Planning Application Reference No.: 03/2022/0799

Address of Development: 39 The Rydings, Langho BB6 8BQ

Planning Application 3/2022/0799

proposed ground floor plan

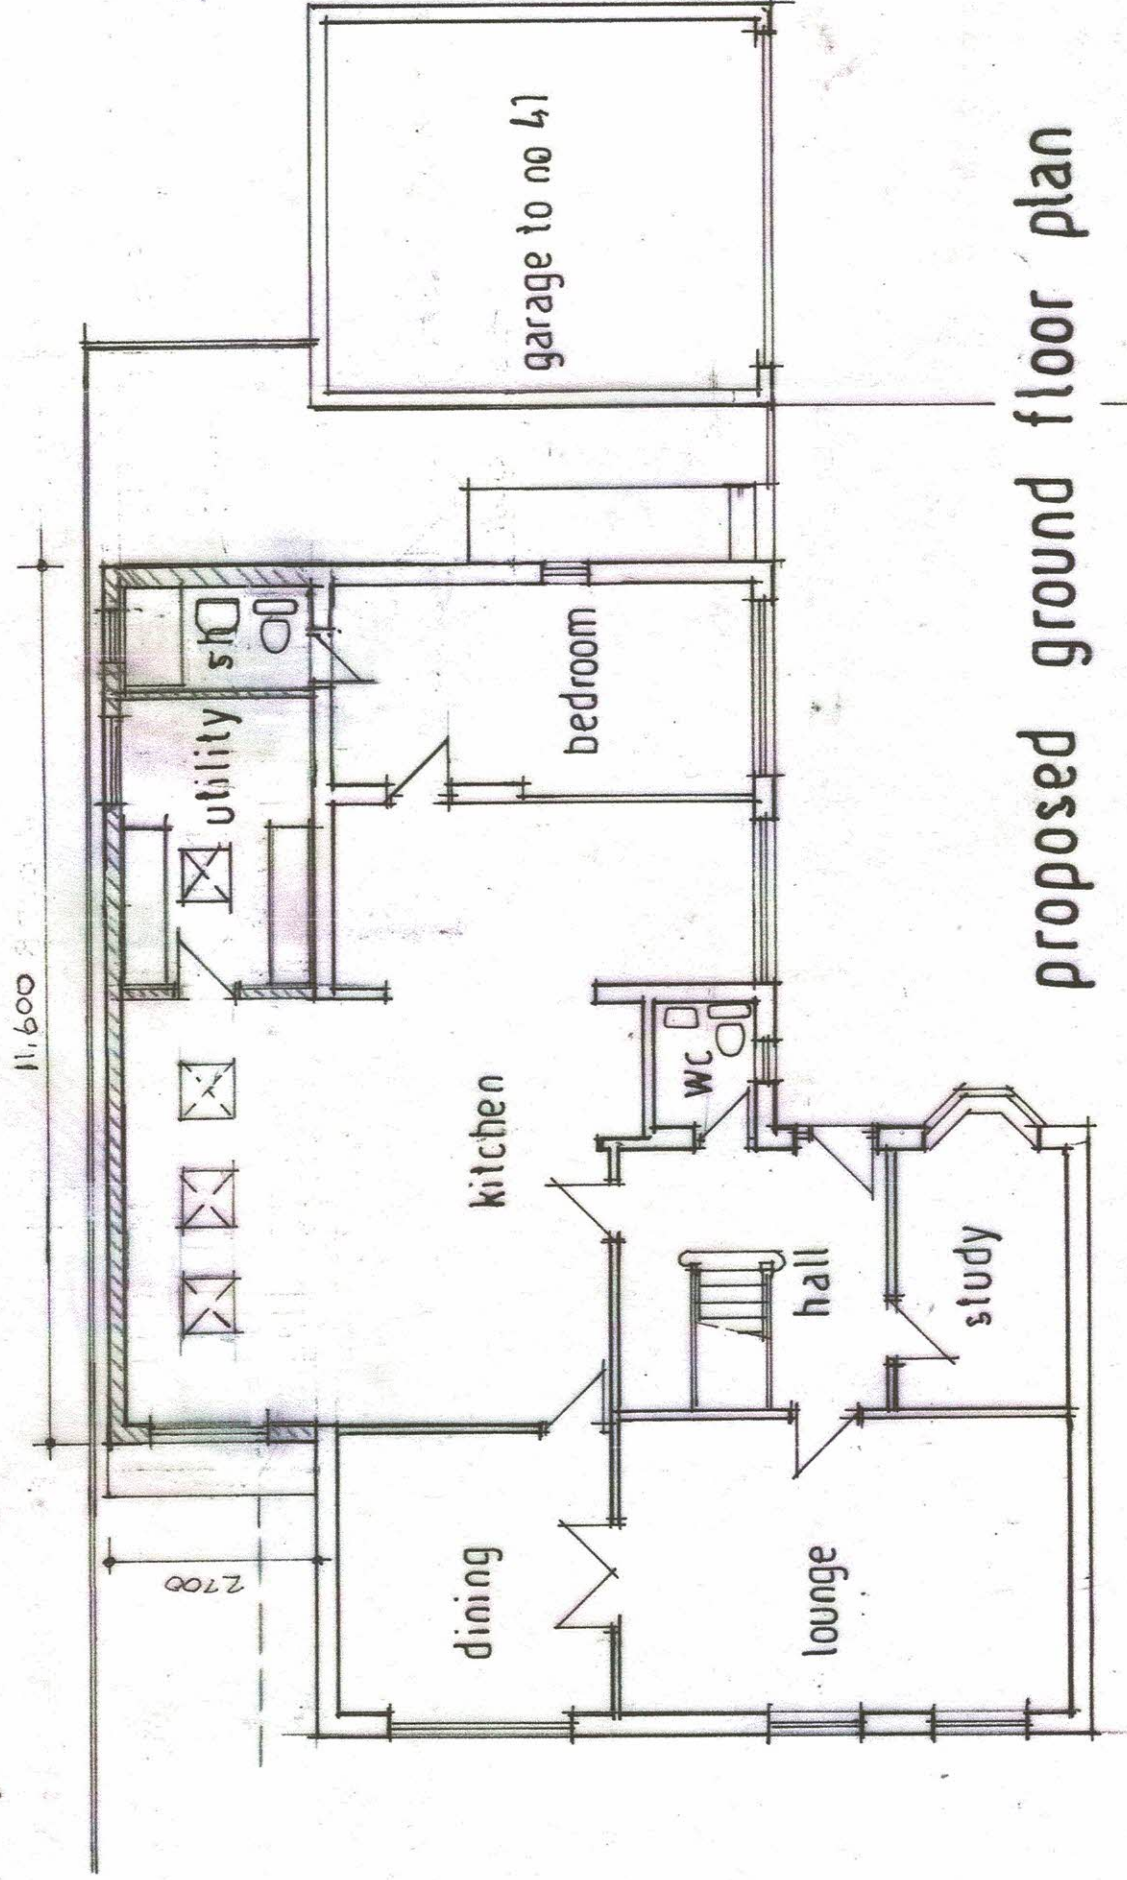
The proposed extension continues to goes against the open plan layout of the estate by cramming in an rear extension all the way to the western boundary fence to [REDACTED]. This impacts both the aesthetics and will be detrimental to the future maintenance requirements of the property.

A key consideration for any project is the impact on future maintenance. No mention is made in the proposal for rain water goods and dealing with water from the roof structures. Because of the proposal to build all the way to the boundary the lack of access for regular inspection and maintenance of any gutters at the rear of the property will be problematic. Currently one of the downspouts to the existing gutter [REDACTED] continues to be blocked with weeds. This leads to water cascading onto the existing hard flagged surface and the ponding of water in the rear garden [REDACTED] where the ground level is a foot or more [REDACTED]. The proposal will only make the existing problem worse and in conflict with Ribble Valley Core Strategy DME6 para 10.17 producing an 'unacceptable risk of flooding or exacerbate flooding elsewhere'.

The site plans for the proposed works indicate that the new rear elevation of the property will only allow for a 200mm gap between borders, a decrease of 2700mm. This is concerning for ██████████ for several reasons:

- a) It appears little consideration has been established regarding how No. 39 proposes to adequately maintain and access the new structure given the proposed inadequate manoeuvring room (leading to objection reason 2).
- b) Site plans illustrate the foundations for the new structure exceed the distance of the façade of the proposed works. As such, excavation activities are likely to infringe the ██████████ Furthermore ██████████ would like to be notified of excavation works by way of a section 6 excavation notice a month before the commencement of works.
